Re: Planning Application 19/0566

Address: 25 Greenacres, Read Burnley BB12 7PT

Description: Two story extension to side with excavated garden banking to increase parking.

New car parking area with car parking set at 4.8m X 2.4m - Zoff using pavlovers or similar on a permeable base

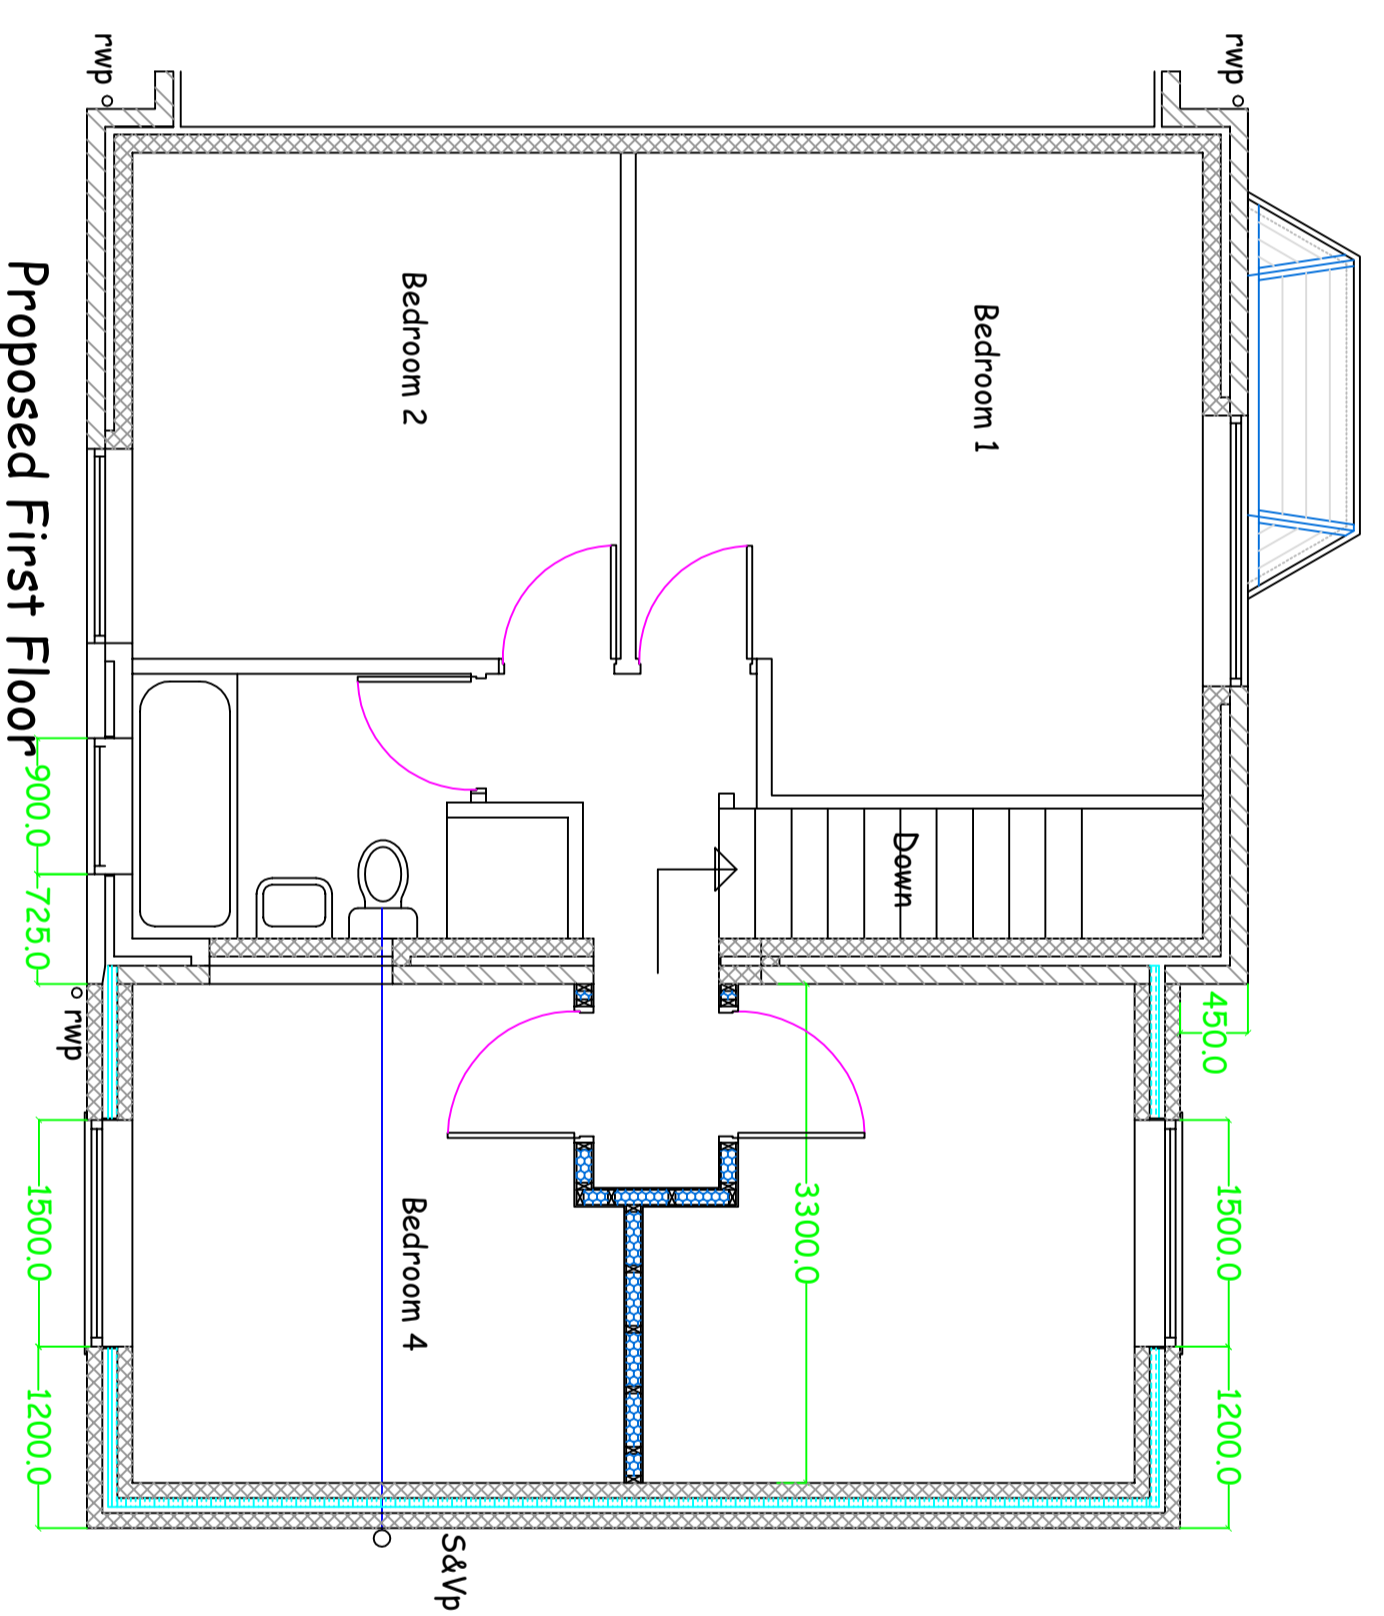
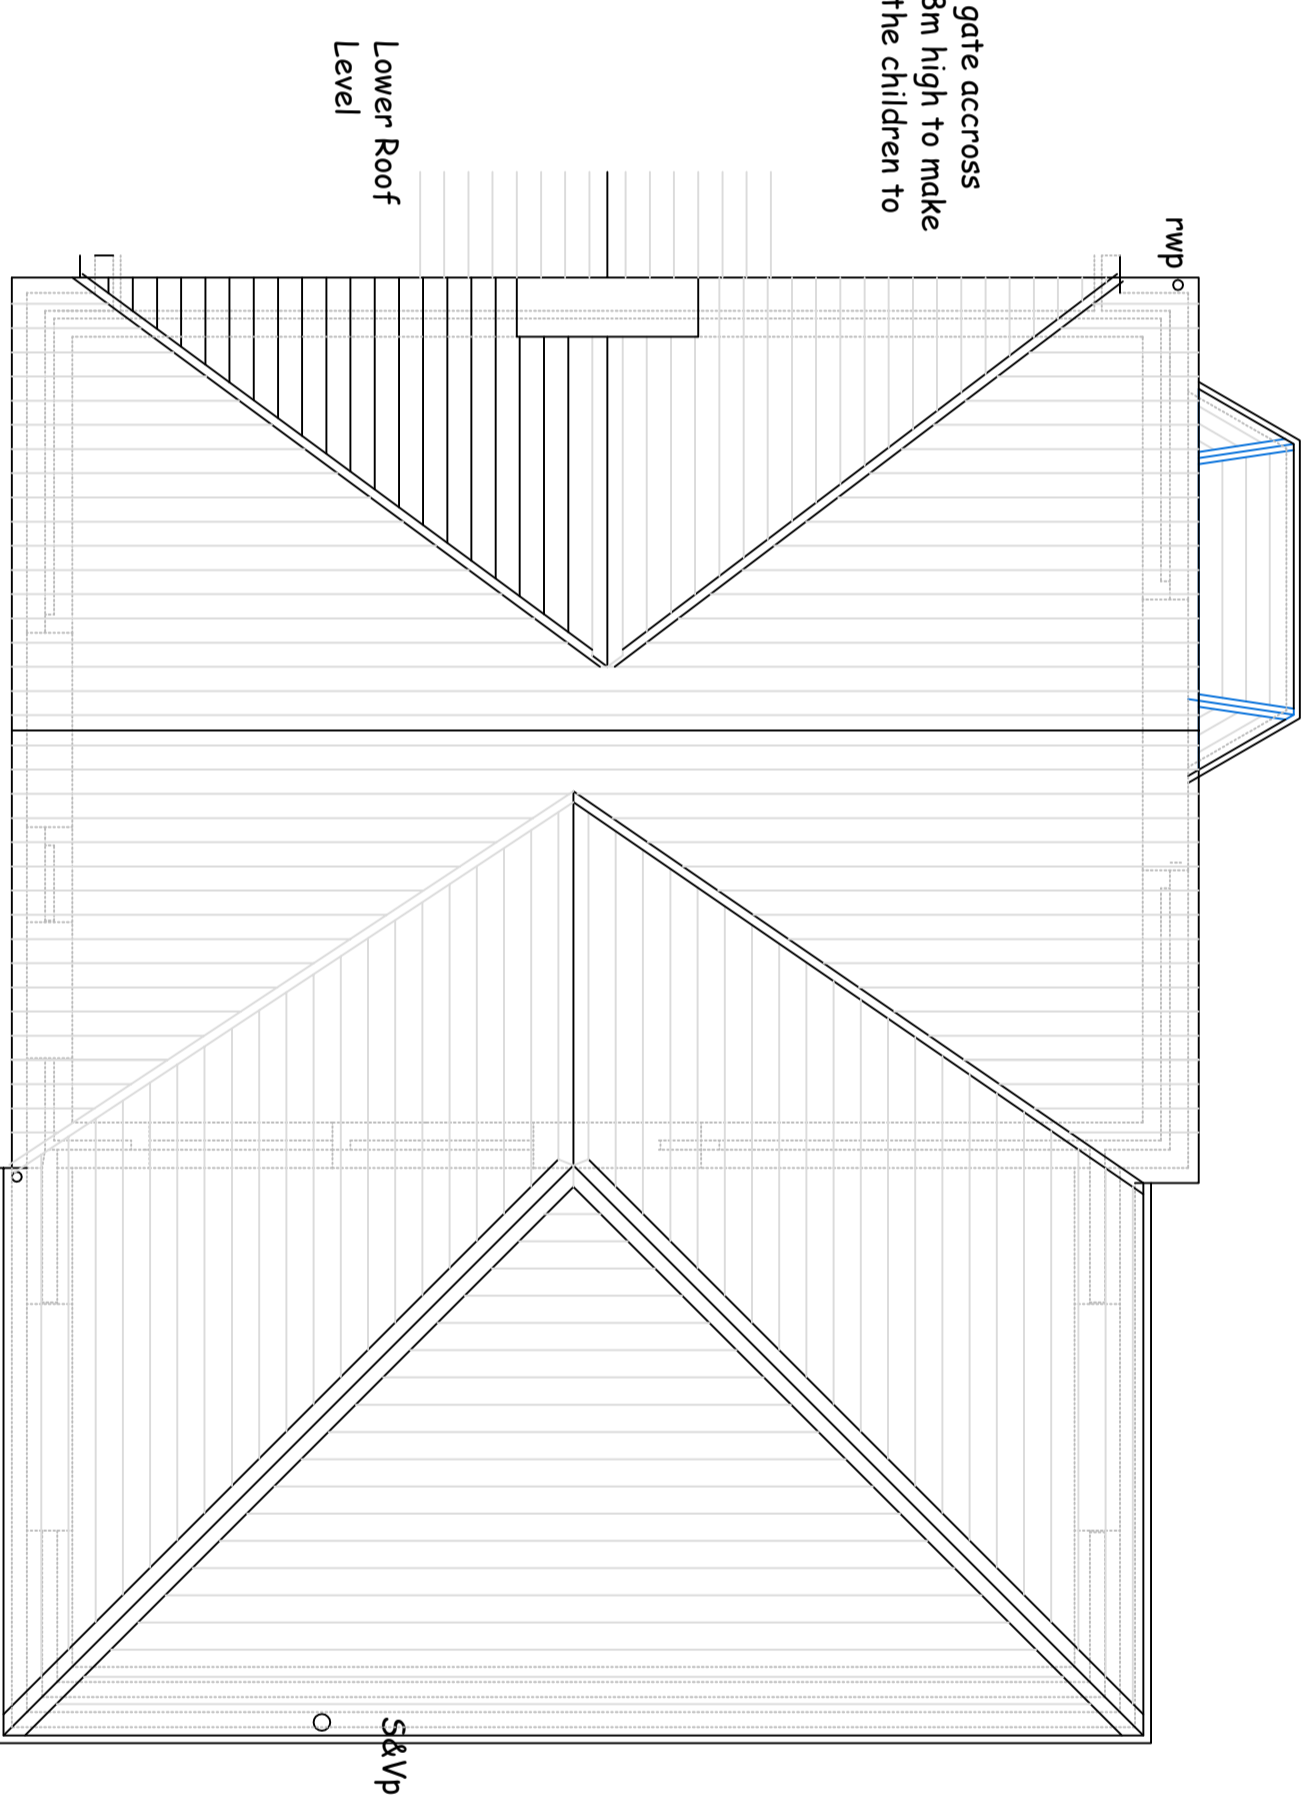
It is noted that there is proposed to be an increase in the bedrooms from 2 to 4 bedrooms. Applying Lancashire's Parking Standards this type of property should be provided with 3 car parking spaces.

These spaces should be a minimum of 2.4m x 5m and where the private drives are sandwiched between walls and fences, it is recommended that the drives to have a minimum clear width of 3.0m, to provide additional room to open the doors.

In order to progress the application we would look for the provision of either additional off street parking or the reduction in the number of bedrooms to 3 which would then only require 2 off street parking spaces.
